From: [REDACTED]
Sent: 02 December 2025 09:03
To: Planning
Subject: Planning Application 3/2025/0887

Dear Ms Walker
Re: Planning Application 3/2025/0887
Construction of a garage in the front garden of 53 Knowsley Rd Wilpshire

2 Garage Attic  
1:50

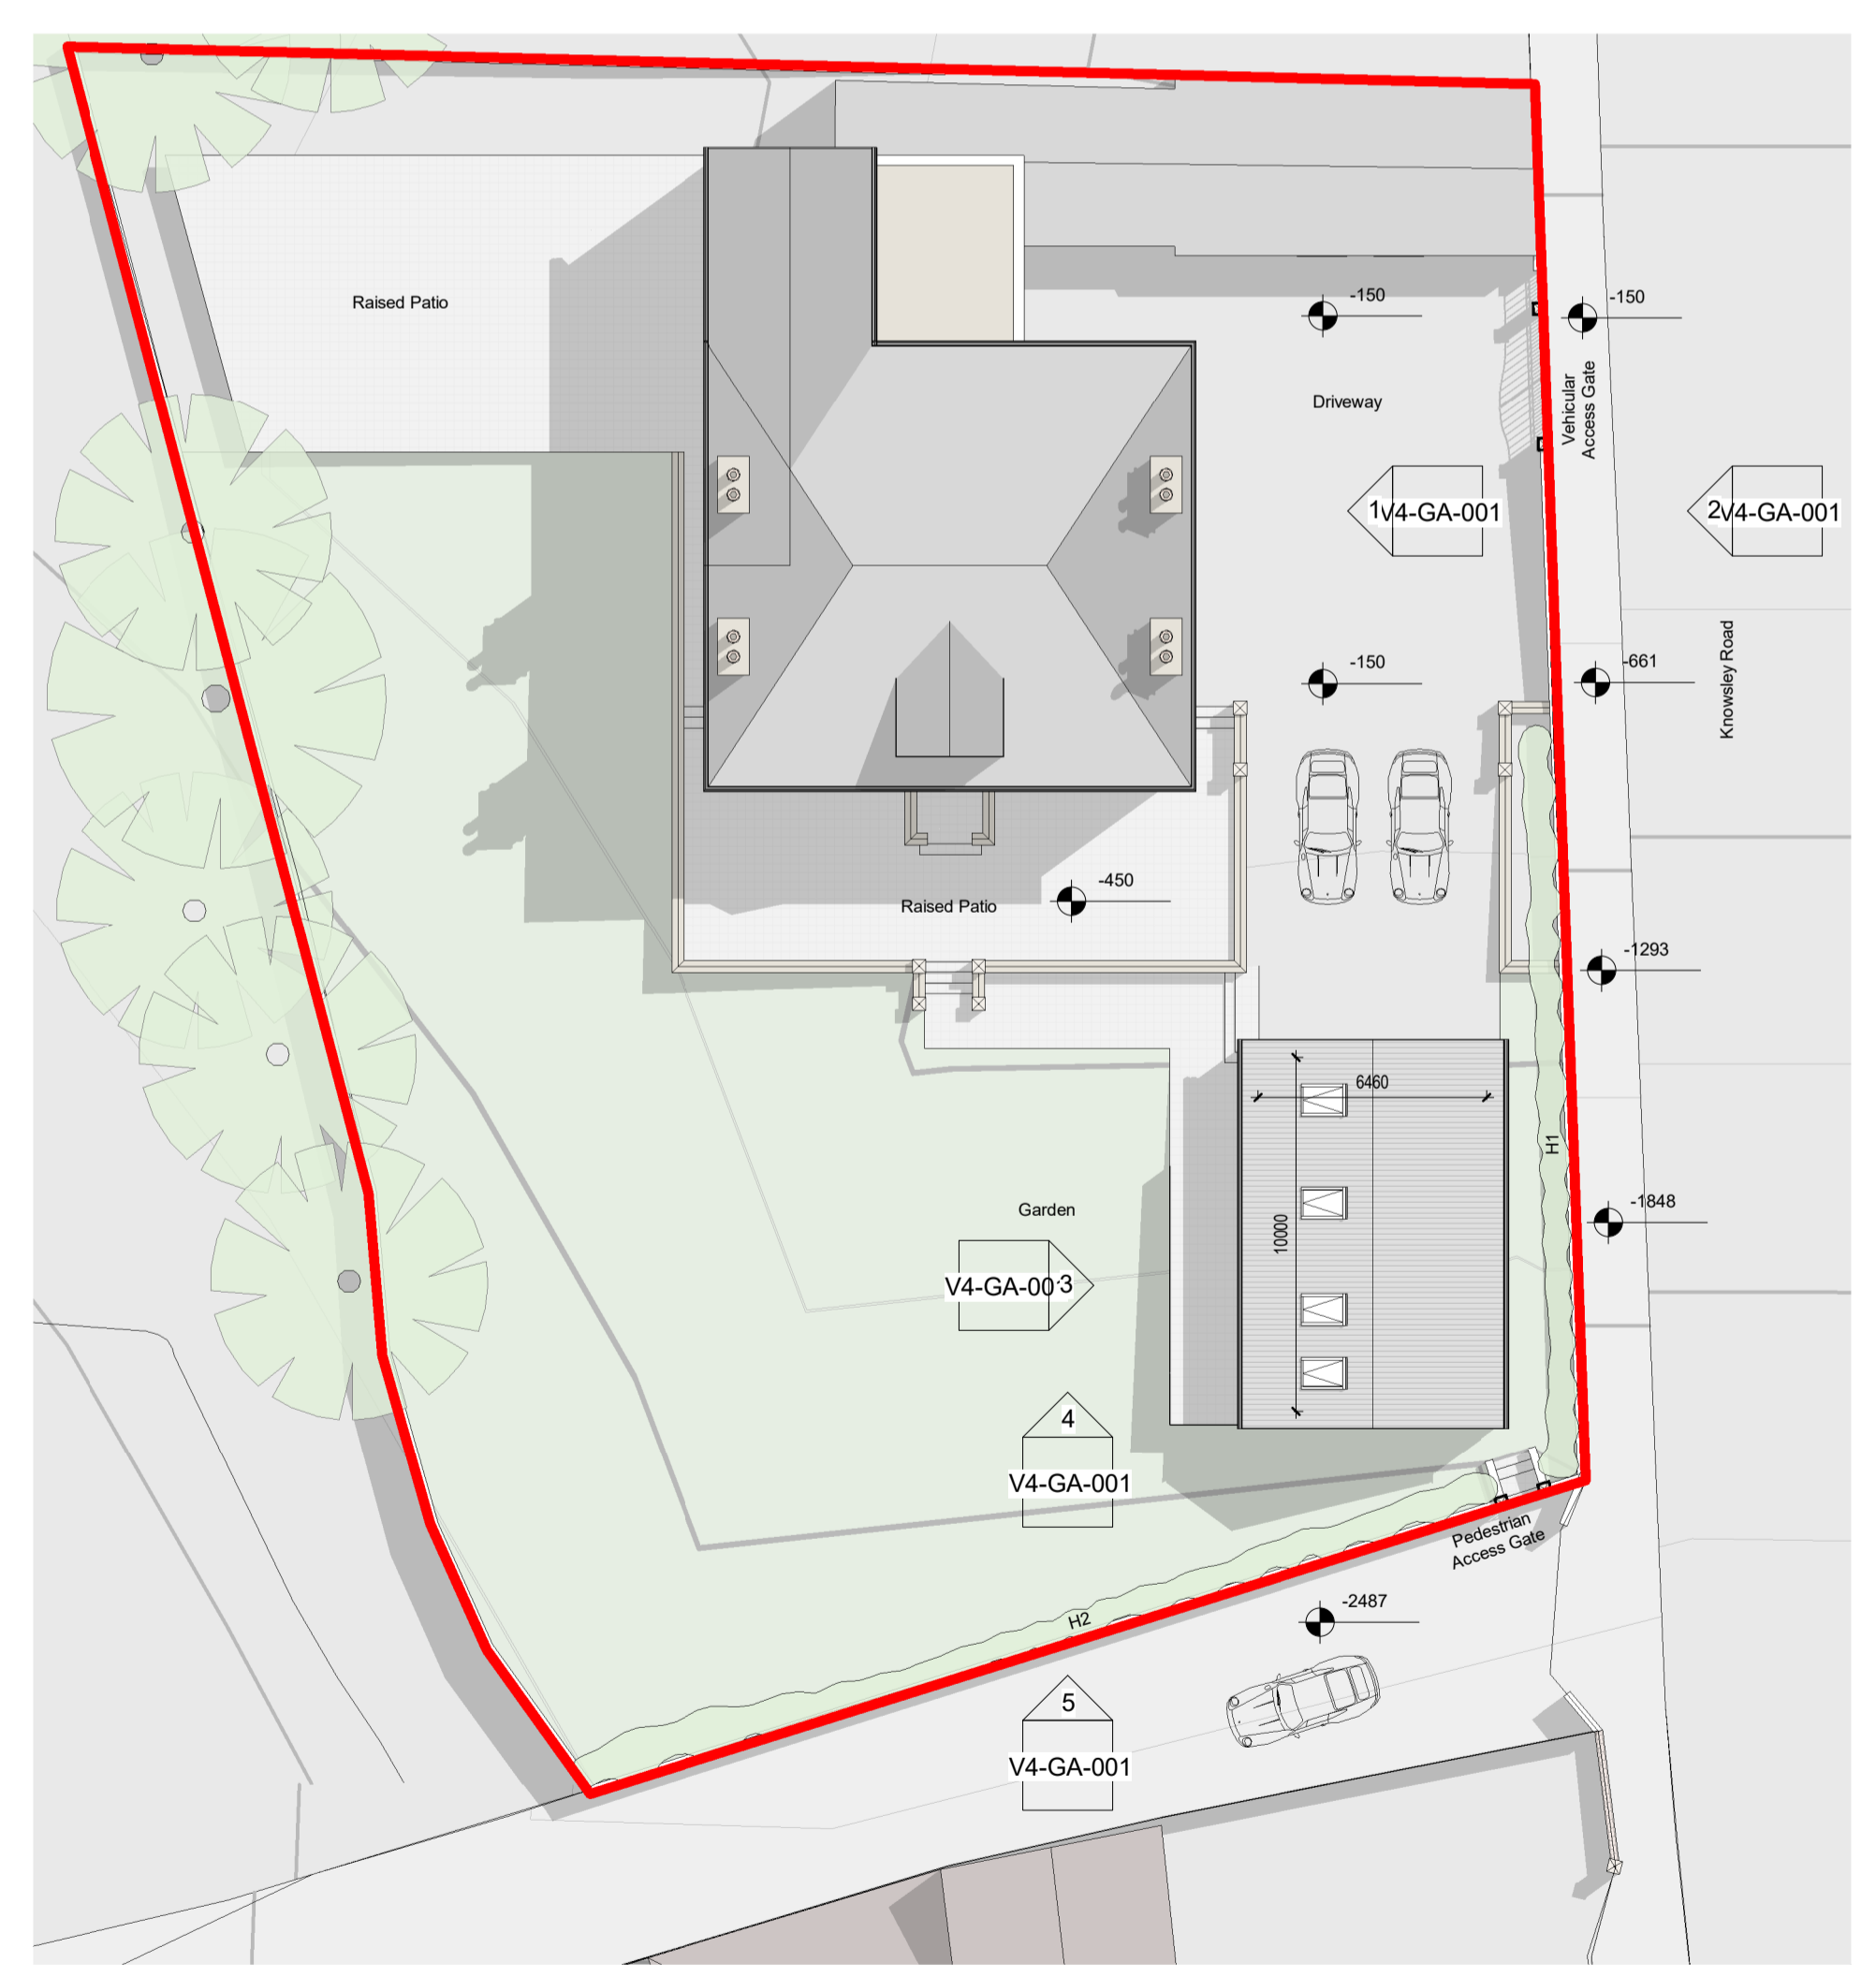
We wish to register our strong objections to the above Application. We find the Application to be very misleading as the description of the proposed work only mentions a garage. It is a two storey property in the front garden of No.53 including a double garage, a large gym, plus an upper floor attic, accessed by an internal staircase. Hardly just a garage.
